From: Ian Gledhill [REDACTED]
Sent: 12 November 2021 16:04
To: Anita Gardner <Anita.Gardner@arun.gov.uk>
Subject: RE: A/169/21/PL - Land south of Littlehampton Road

Whilst some of the following comments will also related to A/168/21 (new access and residential development), those made here relate only to A/169/21 (the new access serving the existing permitted uses). There weren't any great number of issues raised by WSCC Highways with the new access with it intended to serve the existing uses. The issues raised were largely in respects of missing supporting information and procedural matters.

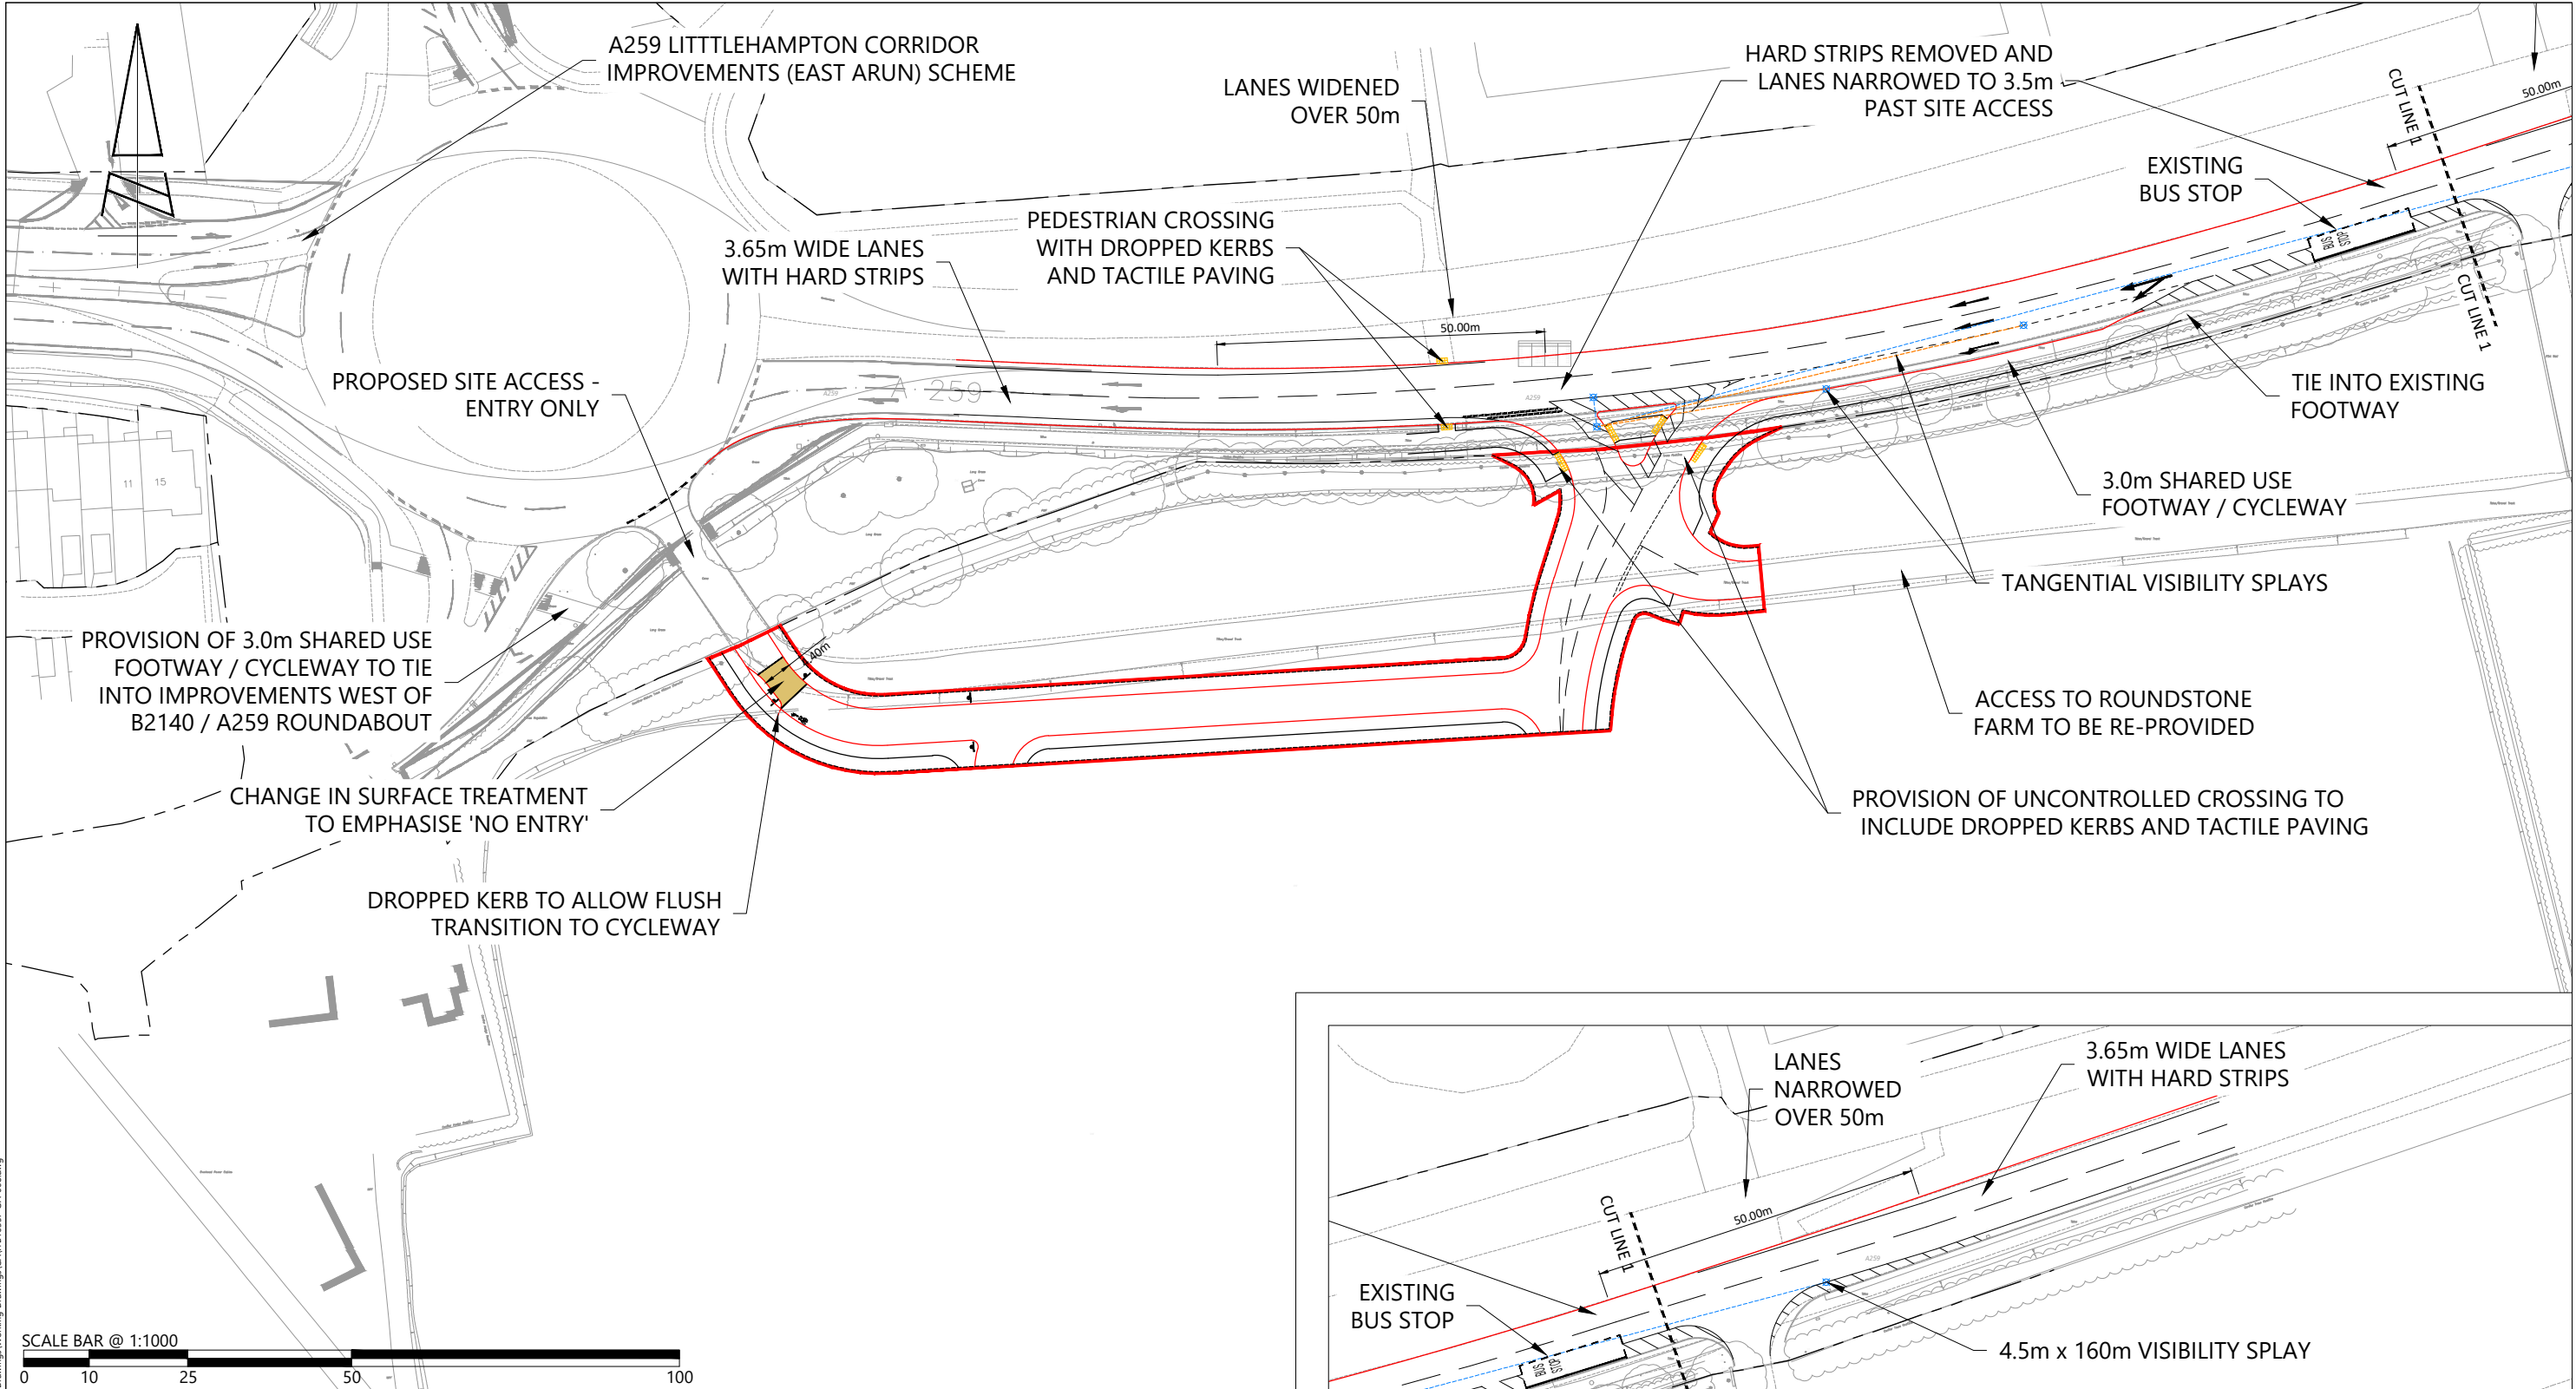
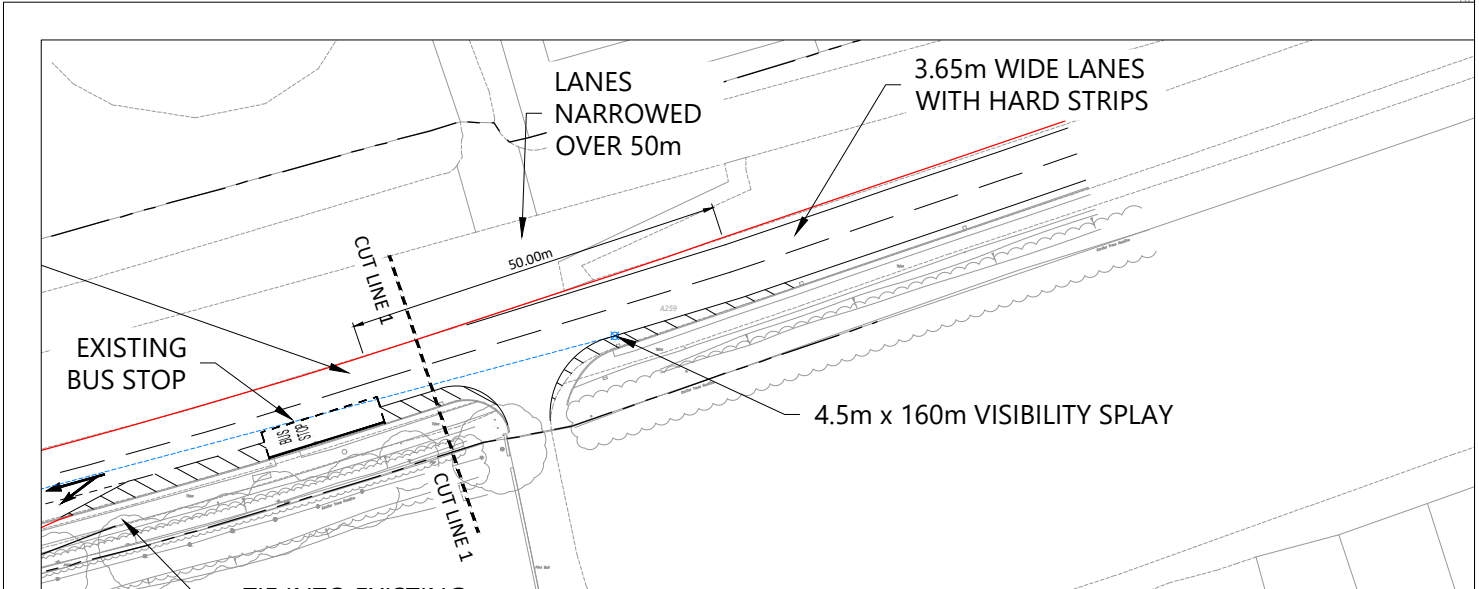
The submitted design audit and associated departures from design standard (DfS) have now been considered. There are two departures relating to the removal of hard strips and narrowed carriageway widths. Unfortunately the two applications for departures have not been accepted. In determining these departures, WSCC consider that the design can be altered, thereby removing the need for any departures to recognised design standards. The scheme designer has been advised of the WSCC decision and the suggested course of action. WSCC wouldn't be supportive of the access in its present form.

Whilst perhaps irrelevant now but just for the file, in terms of more detailed matters, although the existing access located to the east of the proposed access is outside of the current application, there still seems no reason why this could not be closed (notwithstanding the need to accommodate the existing public right of way); the current proposal provides a new link road leading towards these existing uses from the proposed access so clearly the intention or at least there is an ability for the new access to serve these existing uses. If the existing access cannot be permanently closed due to rights of access, it could at the very least be gated with all traffic visiting the site directed to the new access.
